CITY OF ALBUQUERQUE

March 26, 2012

Re: Hampton @25 Grading and Drainage Plan
Engineer's Stamp date 03-19-12 (F-17/D088)

ENGINEER'S SEAL 	HAMPTON INN THE 25	DATE 3-14-12
	GRADING AND DRAINAGE PLAN	21207-LAYOUT-3-12-12
	Rio Grande Engineering 1806 CENTRAL AVENUE SE SUITE 201 ALBUQUERQUE, NM 87106 (505) 872-0999	SHEET # —
	DAVID SOULE P.E. #14522	JOB # 21207

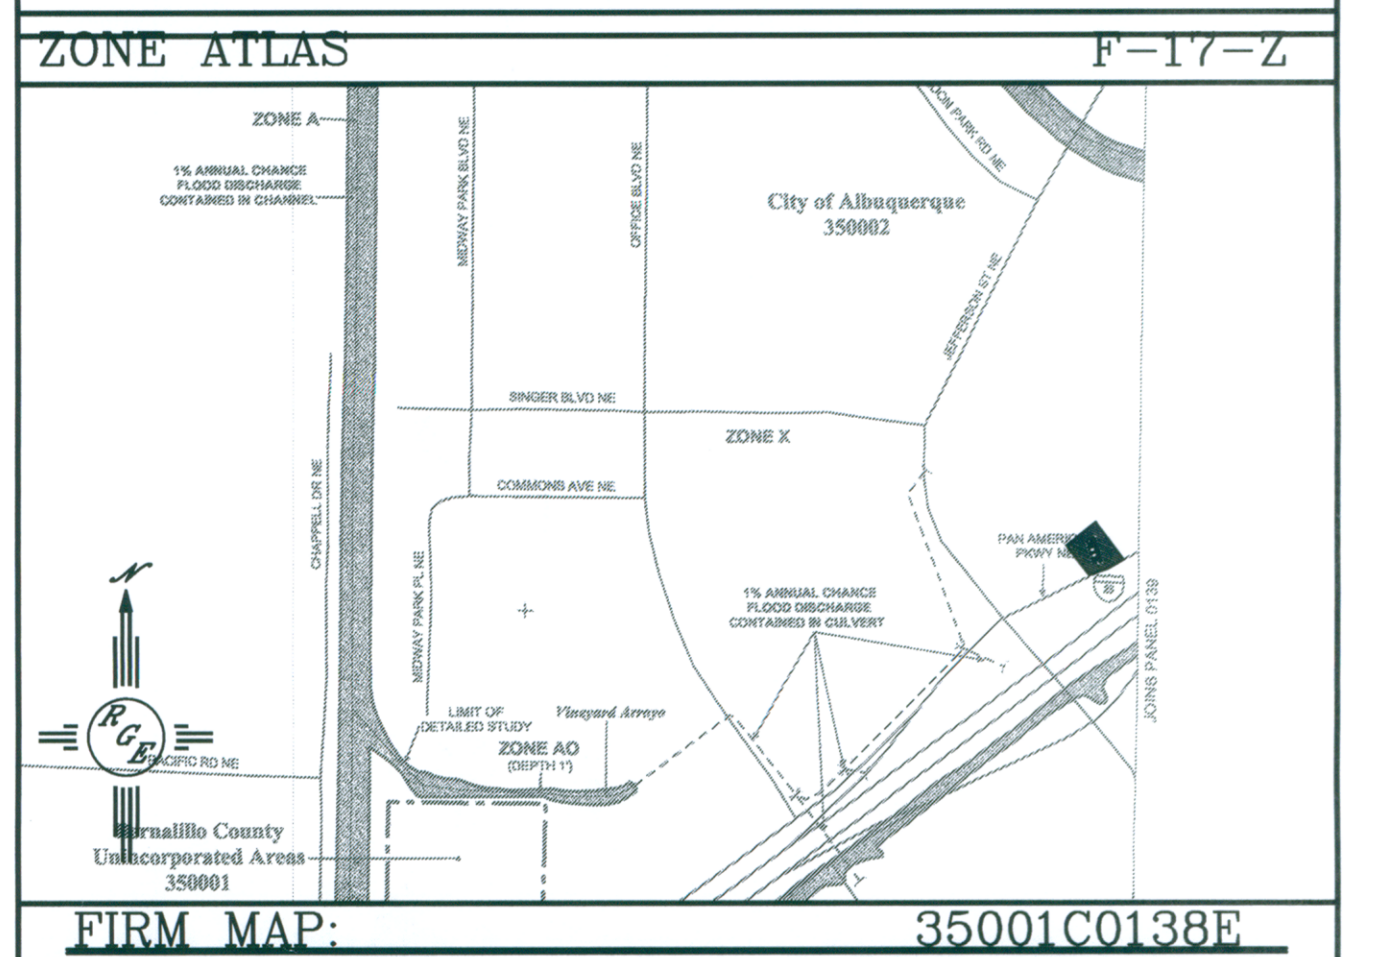
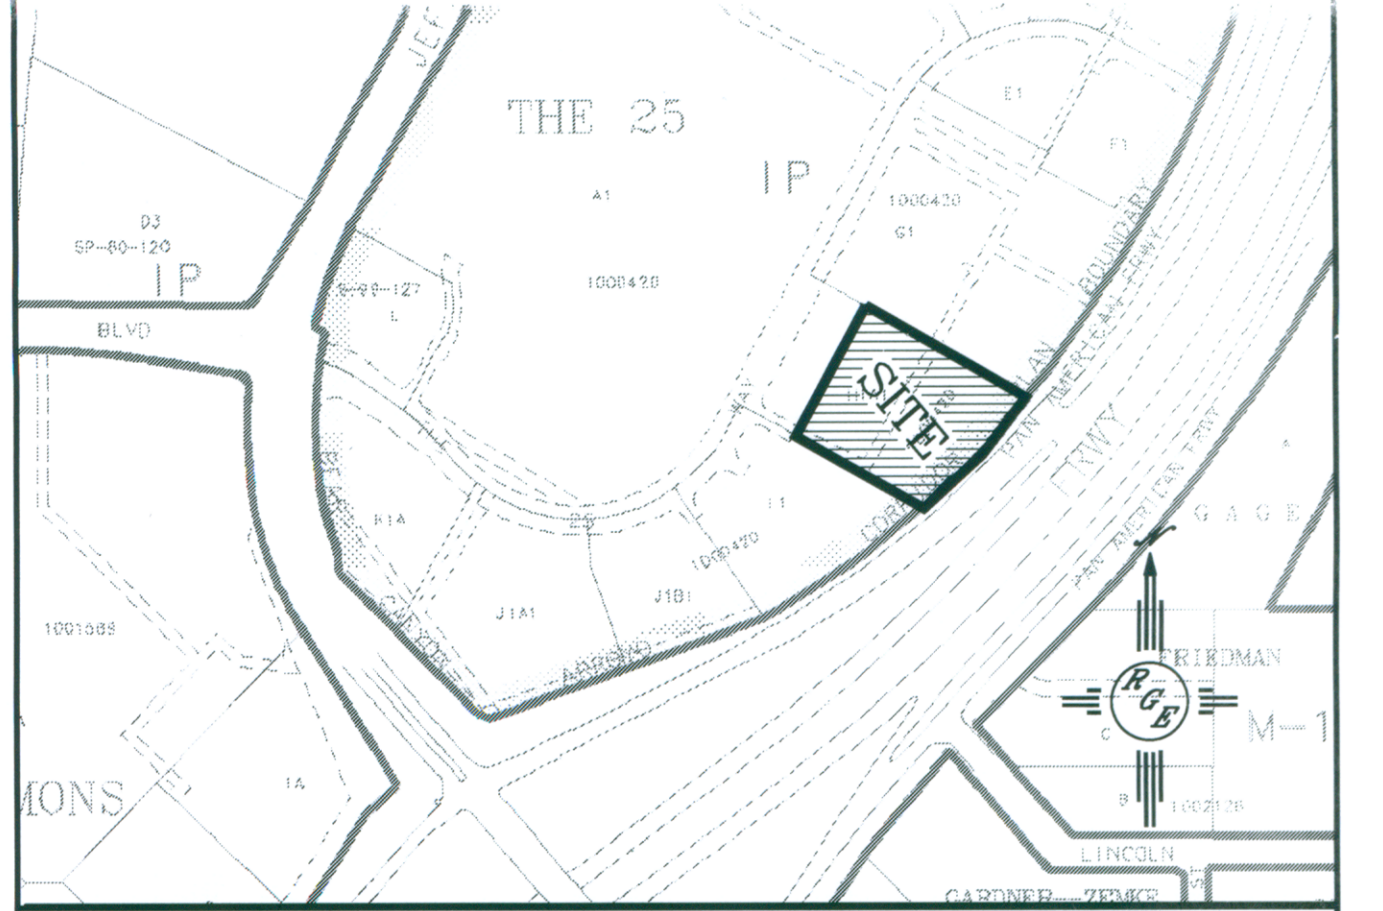
- Indicate the direction of roof flows on the plan.
- Provide details of cobble swale on the southern portion of the site.
- Water block symbol should be added to the legend as well as what appears to be a headwall on the southwest portion of the lot.
- Correct p.3 of the drainage report to indicate that the site drains from northeast to southwest.
- Please show basin boundaries on grading plan.
